City of Portland, Maine - Building or Use Permit Application
 389 Congress Street, 04101 Tel: (207) 874-8703, Fax: (207) 874-8716

Permit No: 07-0555	Issue Date:	CBL: 437 B069001
------------------------------	--------------------	----------------------------

Past Use: Single Family	Proposed Use: Single Family 24' round above ground swimming pool	Permit Fee: \$50.00	Cost of Work: \$3,000.00	CEO District: 4
Proposed Project Description: 24' round above ground swimming pool		FIRE DEPT: <input type="checkbox"/> Approved <input type="checkbox"/> Denied	INSPECTION: Use Group: Type	
		Signature:	Signature:	
PEDESTRIAN ACTIVITIES DISTRICT (P.A.D.)				
Action <input type="checkbox"/> Approved <input type="checkbox"/> Approved w/Condition <input type="checkbox"/> Denied				
		Signature:	Date:

Dept: Zoning **Status:** Approved with Conditions **Reviewer:** Marge Schmuckal **Approval Date:** 05/29/2007

1282 Washington Avenue Plot Plan

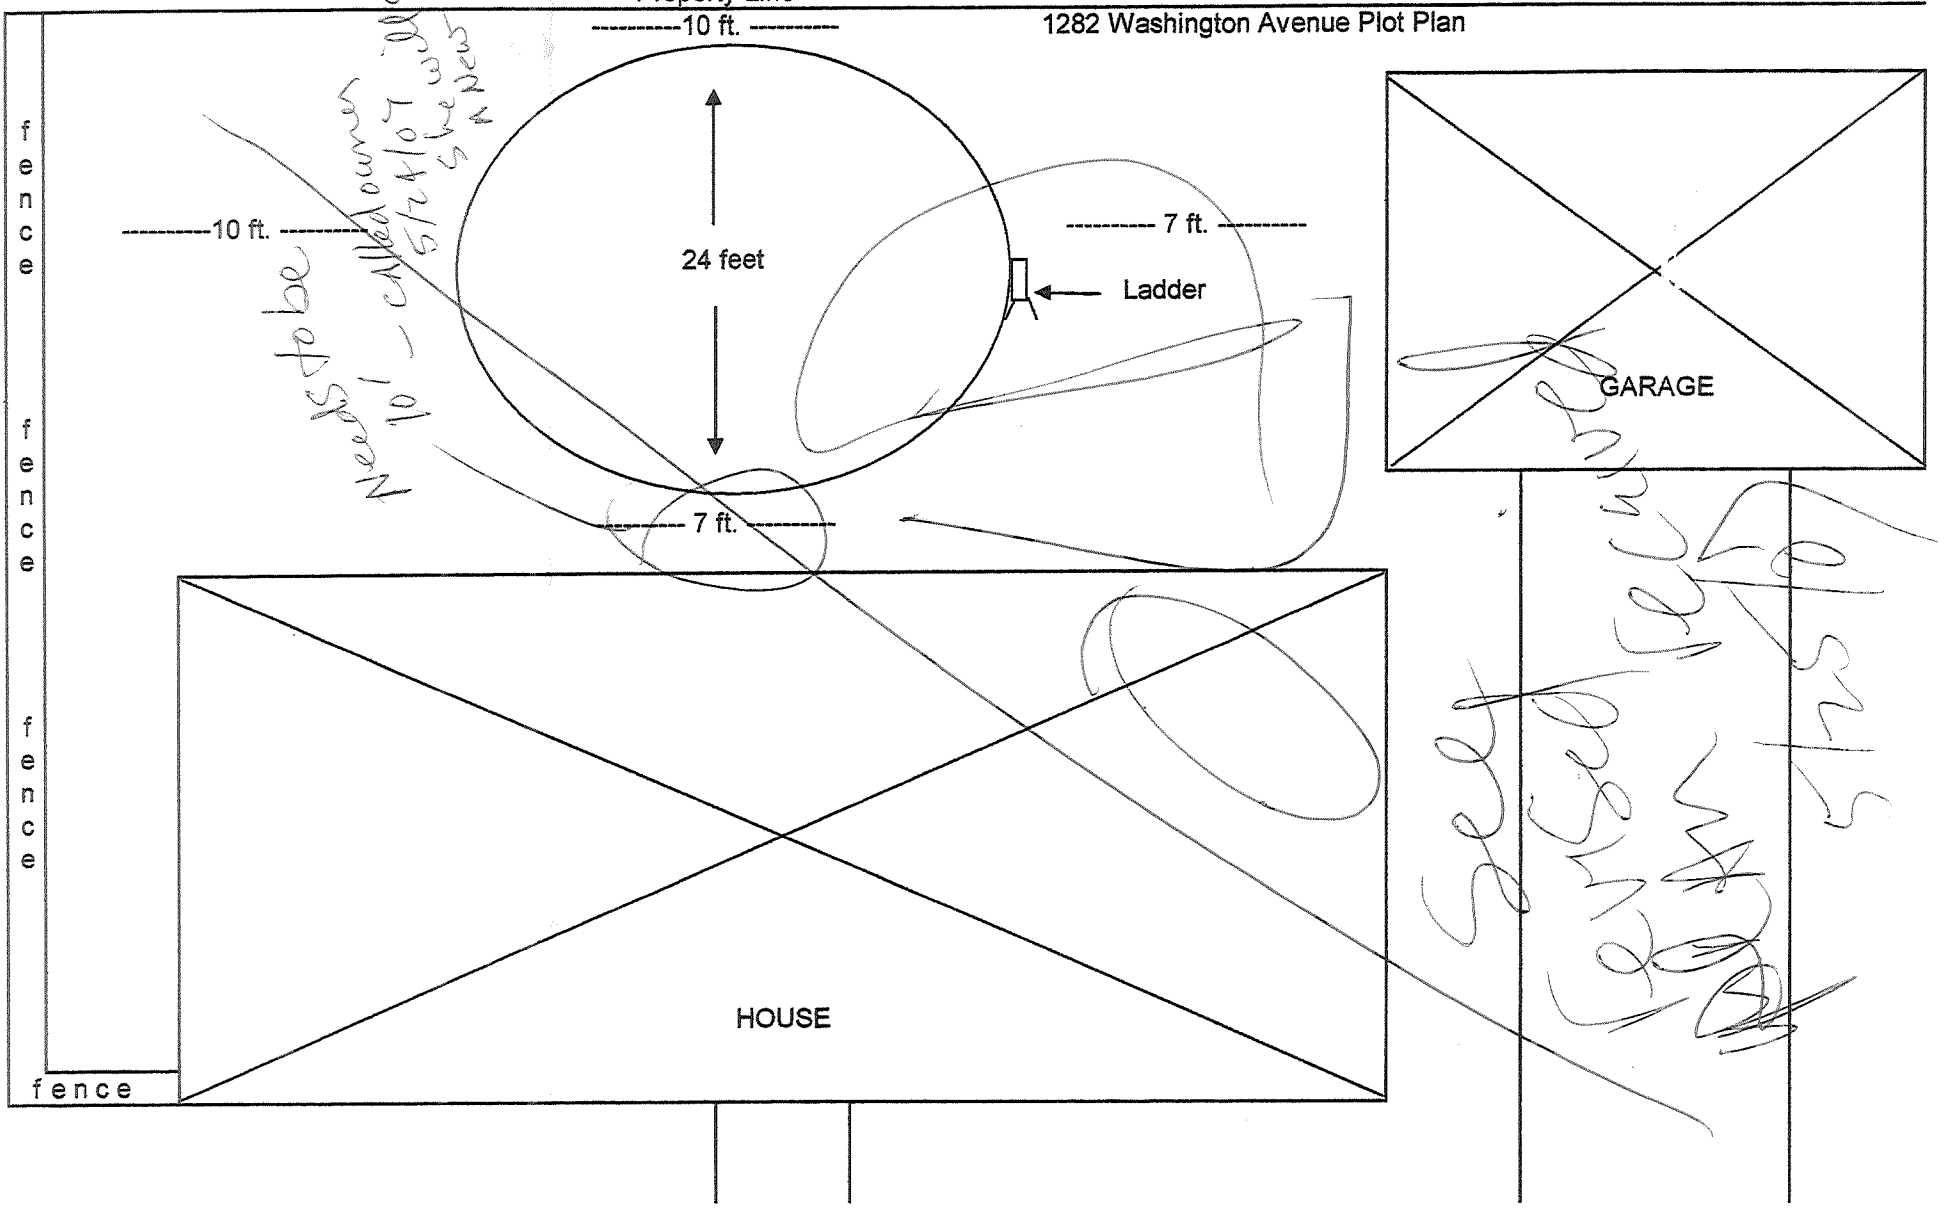
5/24/2007-mes: 5/24/07 called the owner - needs to have 10' between the pool and the principal structure, only showing 7'. She will remeasure and talk to her pool guy and will be sending me a revised plan.
